Site Development Plan_V2 REDLINES.pdf Markup Summary

County File No. PRR244

DEVELOPMENT PLAN

SITE PLAN

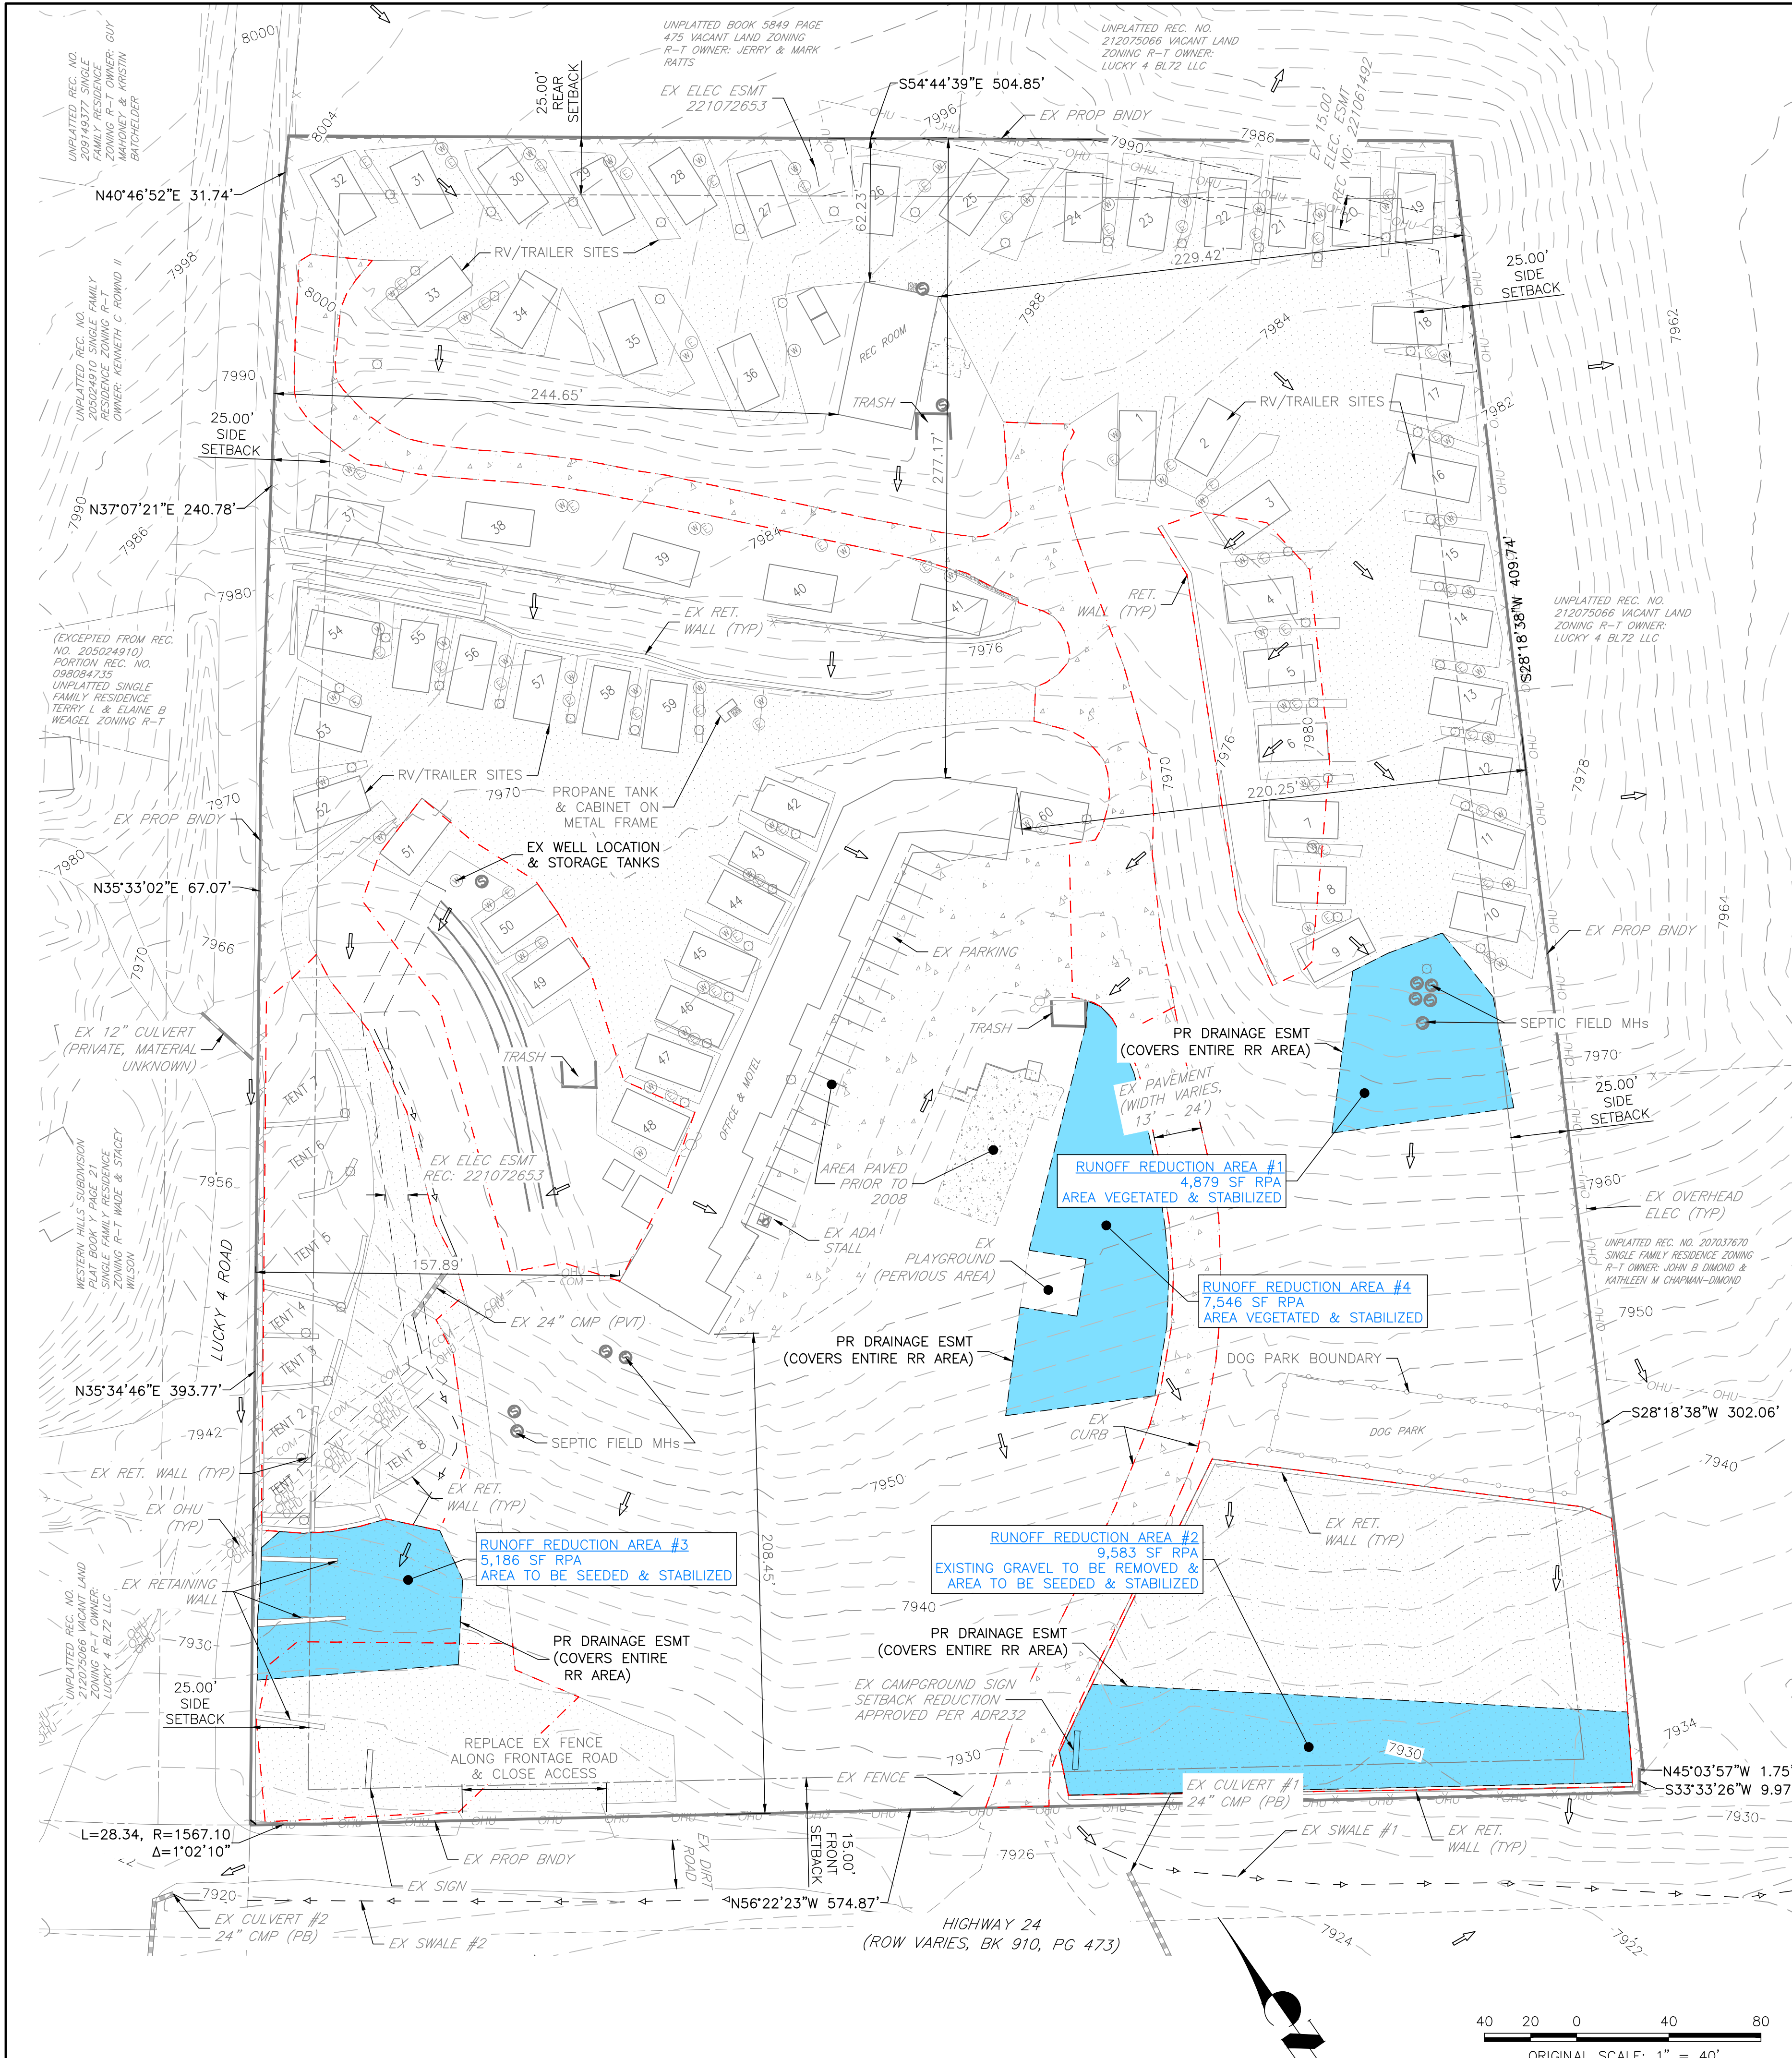
Per SDP checklist, please add contact telephone number and email address

Per SDP checklist, please include open space, landscaping, and impermeable surface percentage calculations

Confirm the screening fence is opaque

Per SDP checklist, insert a signature block for Planning and Community Development Director (1" x 2")

Per SDP checklist, cite both "existing" and "proposed" zoning and land use- even if remaining the same

Per SDP checklist, a graphical depiction of the screening mechanism is required on the site development plan.

Please show proposed/existing light poles

Per SDP checklist, insert the adjoining public ROW dimension

Per SDP checklist, please show ADA pathways

Please provide parking space dimensions

Per SDP checklist, provide setback distances to property line from each existing and proposed structure
